East Anglia One North (EA1N) and East Anglia Two (EA2) Offshore Wind Farms

Planning Inspectorate Reference: EA1N – EN010077, EA2 – EN010078

Deadline 7 – 4 March 2021

Comments of Suffolk County Council as Local Highways Authority

MARLESFORD MITIGATION SCHEME (A12)
PRELIMINARY DESIGN
(SHEET 1 OF 2)

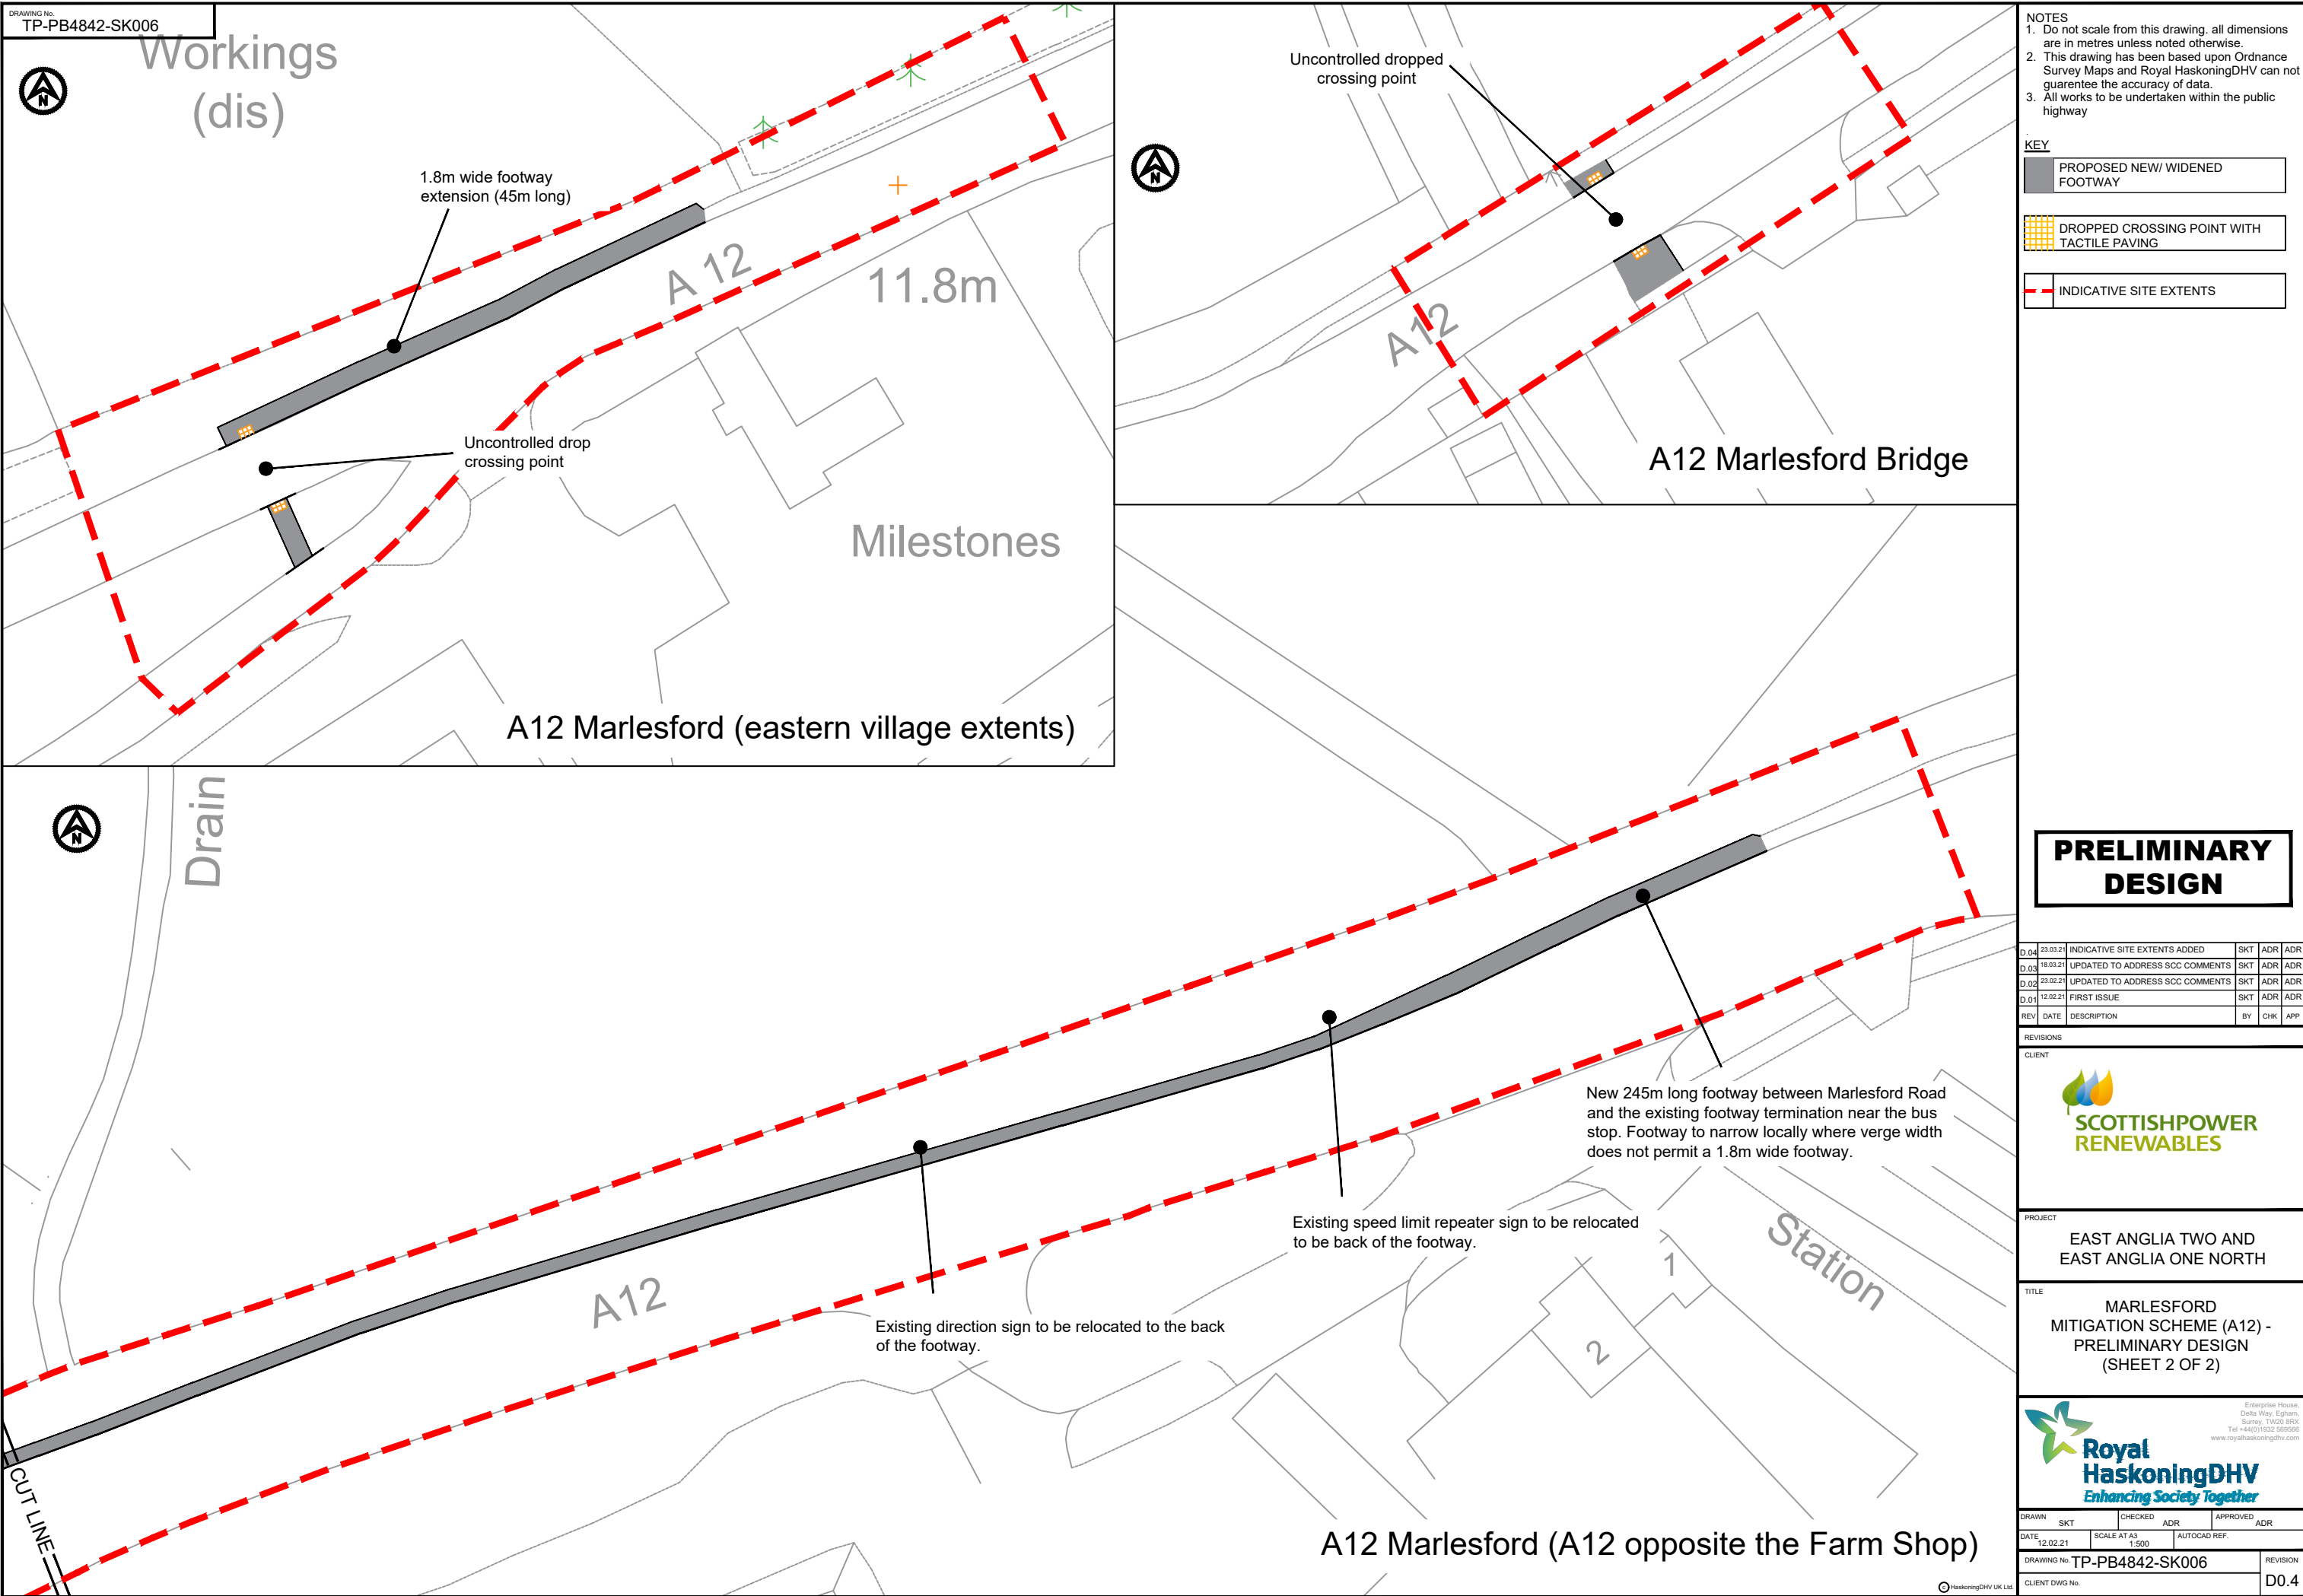
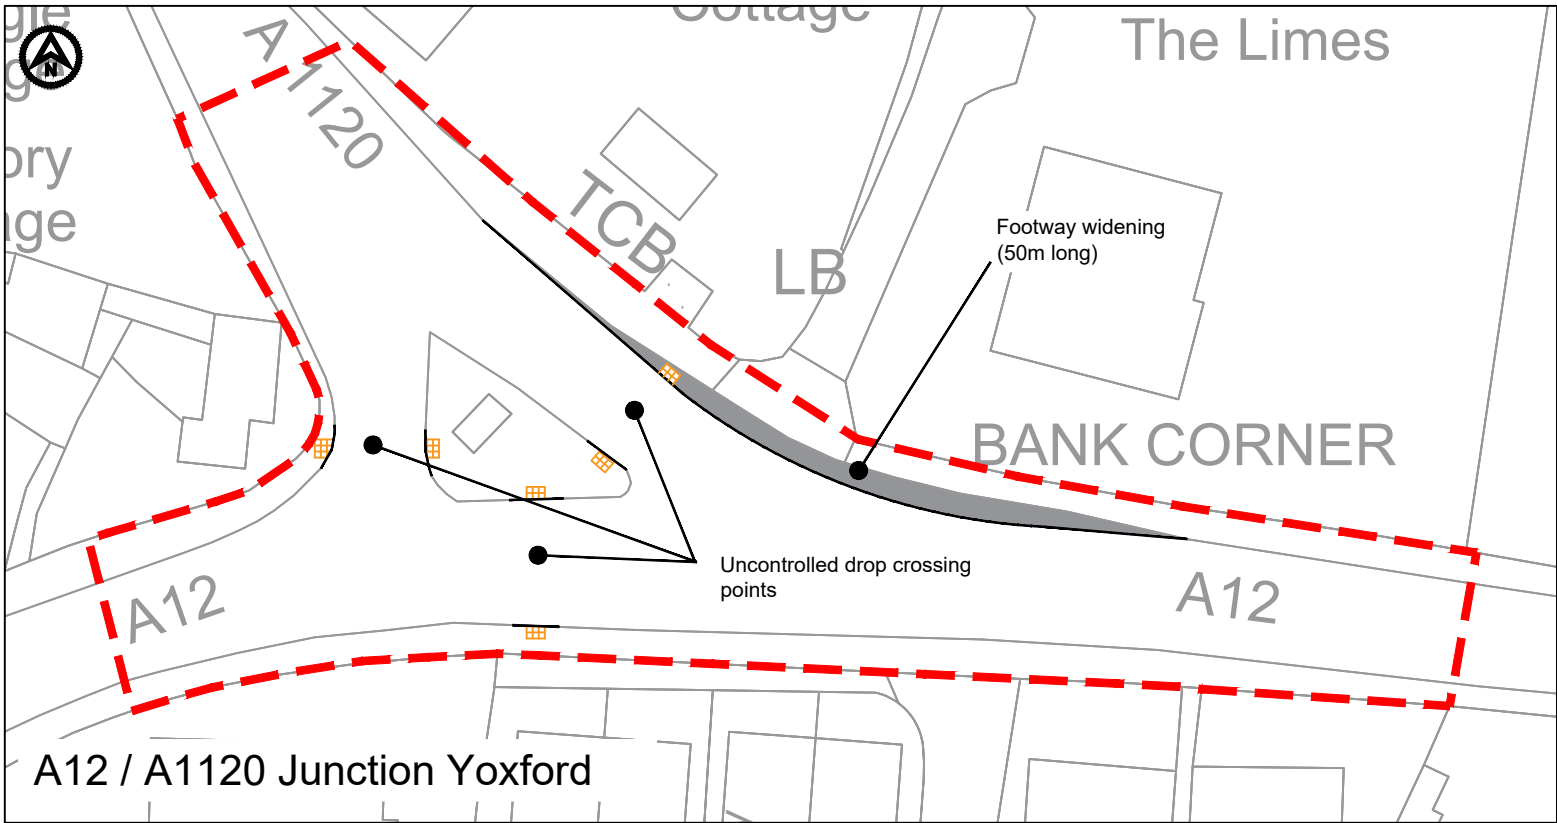
- 2.30 In principle the Council welcomes inclusion of the Marlesford and Yoxford Amenity improvements to mitigate the cumulative impacts in combination with Sizewell C although some minor detailed design matters are still to be agreed. The LHA is of the view that there will be a point in time at which the likelihood of the temporal impact referred to in paragraphs 93 and 97 can be assessed and that time is immediately after a decision is made by the Applicant and EDF to proceed with the projects, if permitted.
